**Drax Bio-Energy and Carbon Capture Storage**  
**Deadline 1 – Summary of Relevant Representations**

Appendix A is a tabled summary of written representation's submitted by North Yorkshire County Council and Selby District Council (The Authorities) on 5<sup>th</sup> September 2022

**Michael Reynolds**  
**Senior Policy Officer (Infrastructure)**  
**North Yorkshire County Council**

Drawing file: published-documents / EN010120-000170-6.2.5.6 Drax BECCS ES Vol 2 Figure 5.6 Abnormal Indivisible Load Routing.pdf

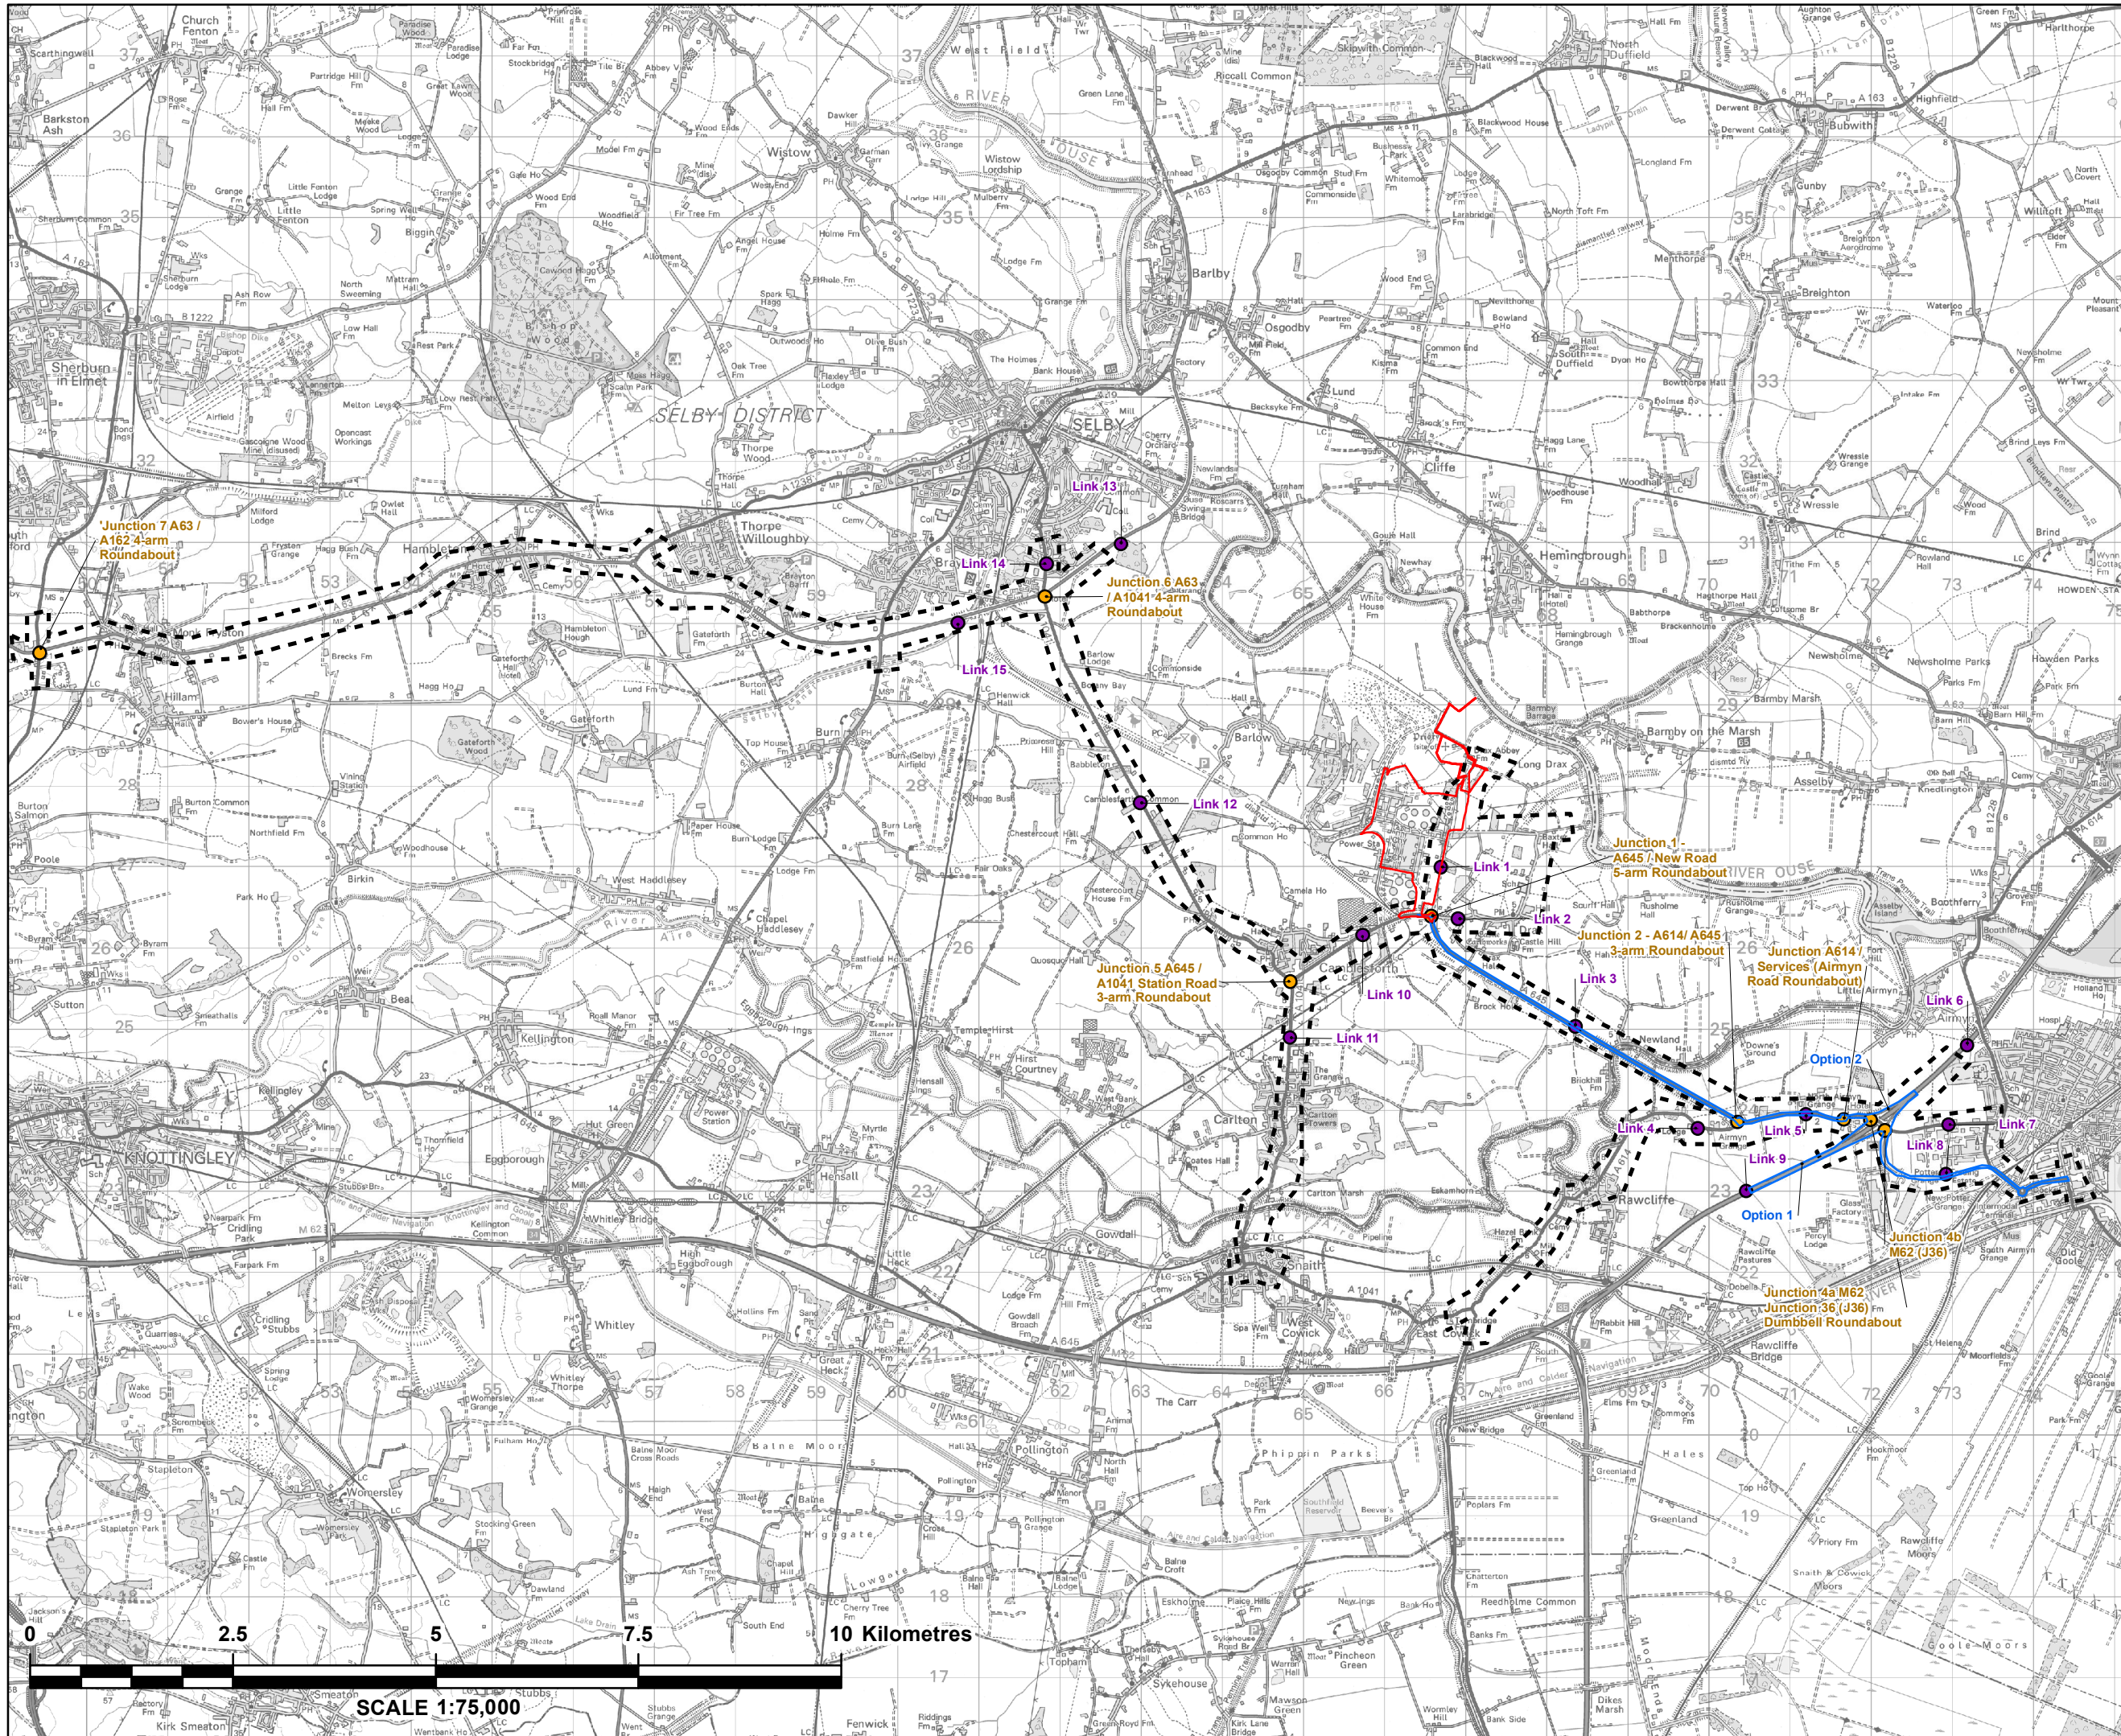
The routing of abnormal loads to the site will close New Road from the M62.The Highway authority will expect this work to be managed by the developer and consult with LHA when such work is to be programmed.
Public Rights of Way	The Authority recognises the need to temporarily close 35.6/6/1. It will be necessary for the closure to be managed in accordance with local policy and legislation. The Authority looks forward to working with the applicant to ensure the necessary procedures are in place and secured through the DCO. There are minor items which may need to be discussed concerning the description of some of the routes effected. Overall the mitigation measures proposed seem appropriate to the scheme.
